18 July 2019

RE: Sydney Football Stadium (Stage 2 Design, Construction and Operation) – SSD-9835

RE: Sydney Football Stadium Modification 2 (SSD 9249-Mod-2)

Figure 4.2: Sydney Water Diversion Plan showing existing stormwater main (thin blue line), and proposed (thicker blue line) (Source: Aurecon 2019, DWG-CC-00041-B, 25.4.19)

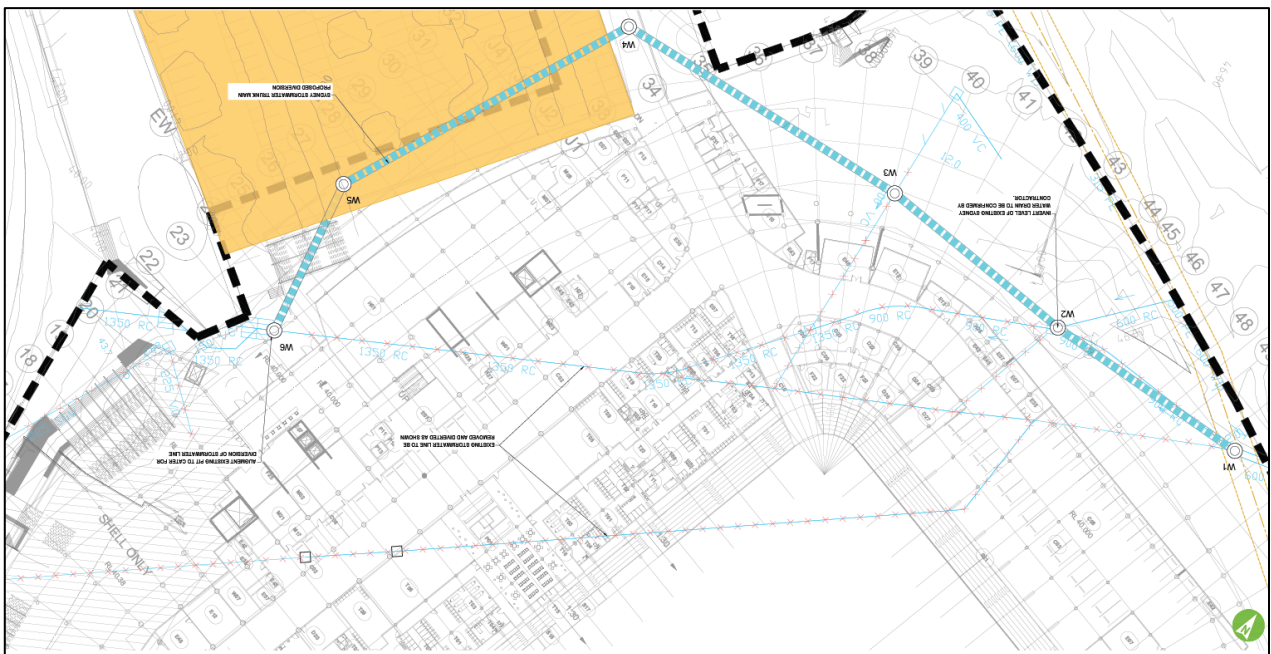
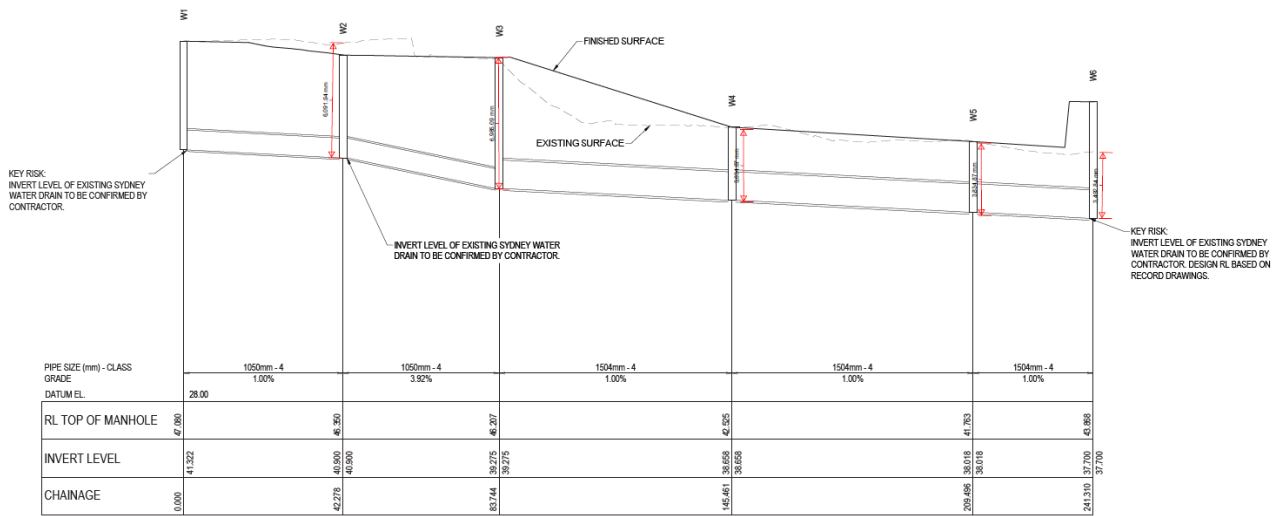
The proposed development requires deviation to a major stormwater infrastructure owned by Sydney Water as identified under SSD 9249-Mod 2 (see attached letter from Sydney Water). Sydney Water does not object with the proposed diversion of its stormwater assets. The developer has submitted an application directly to Sydney Water for the proposed deviation works. Sydney Water is currently working with the developer during the development of the design for the deviation to ensure the works meet Sydney Water's requirements.

The proposed works include deviation to a major stormwater infrastructure owned by Sydney Water. Sydney Water does not object with the proposed diversion of its stormwater assets however, prior to any further approvals the applicant must address the following Sydney Water requirements:

- **Hydraulic Capacity Feasibility Study**
This study must demonstrate that the hydraulic capacity and performance of the existing stormwater system will not be impacted. This ensures the existing capacity of the stormwater system is maintained.

- **Disconnection / connection methodology**
Clearly describe and specify how disconnection / connection of Sydney Water's stormwater assets will take place.

- **Backfilling**
Plans must provide detailed specifications for any redundant pipes that will be backfilled.
